Development Facilitation Team (DFT) – Review Comments

DRB Project No: PR-2021-006308 Date: 09-27-2023 Agenda Item: 6 Zone Atlas Page: C-19

Application For: SD-2023-00159 – Preliminary Plat (DHO)

DRB Project Number: 2021-006308
Wyoming and Alameda

Sidewalk Exhibit

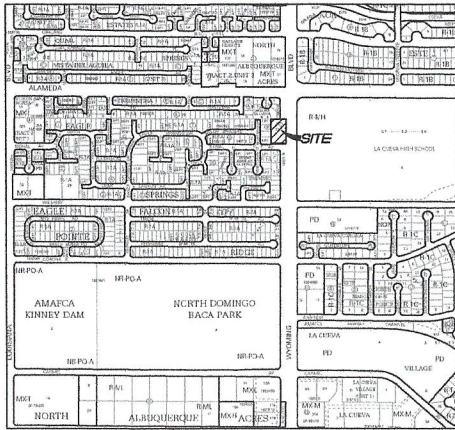
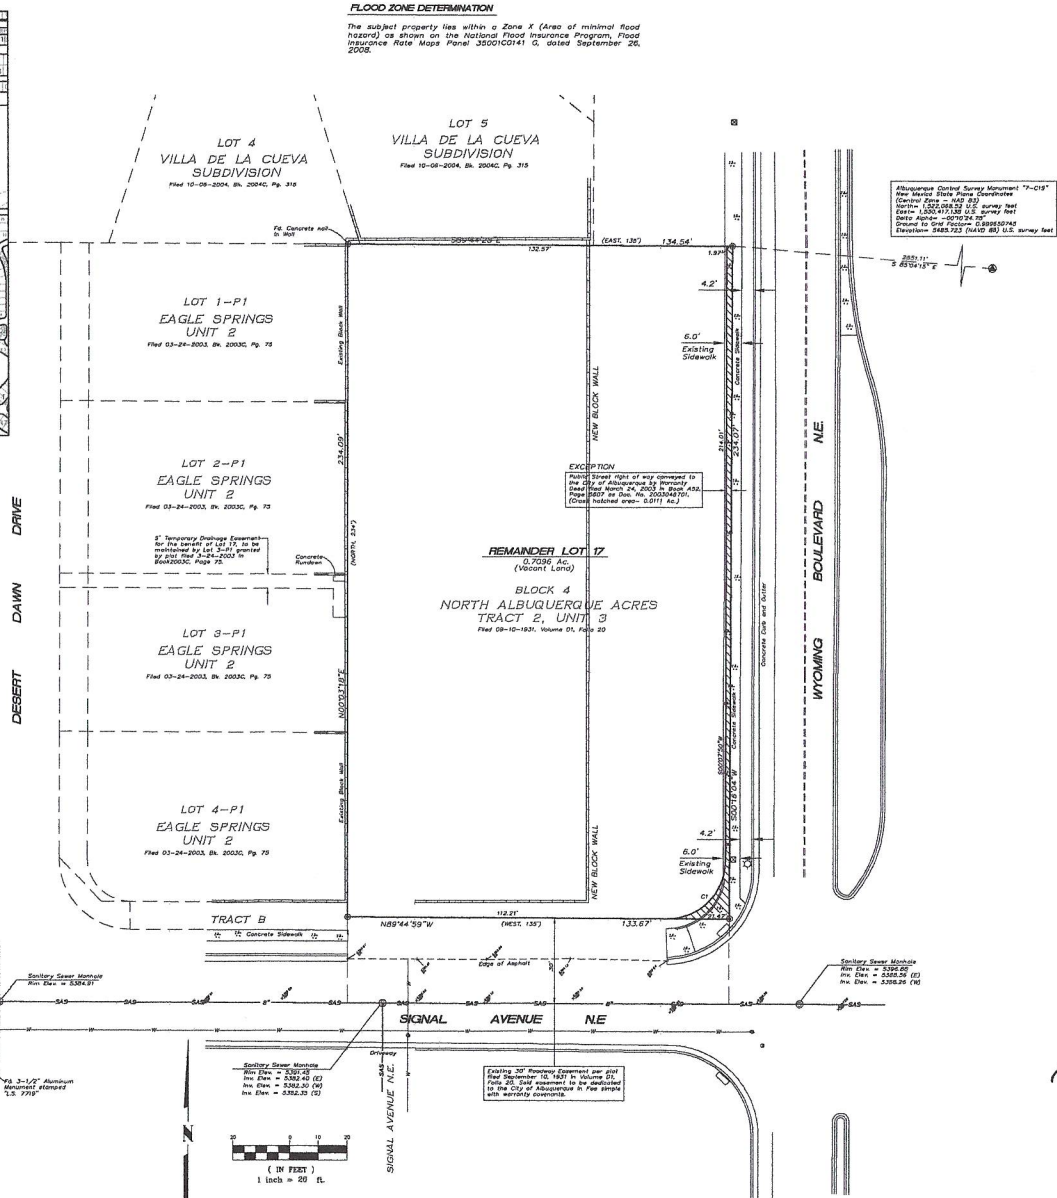
1. Transportation is satisfied with the justification for the 4.2' landscape buffer and defers to Park and Planning if they have any objections.
2. All other comments have been addressed. No objection.

- ***Please confirm ROW development detail and the compliance of section 7 of the DPM, Table 7.2.29. In regards to Sidewalk width requirements and its landscape buffer.**
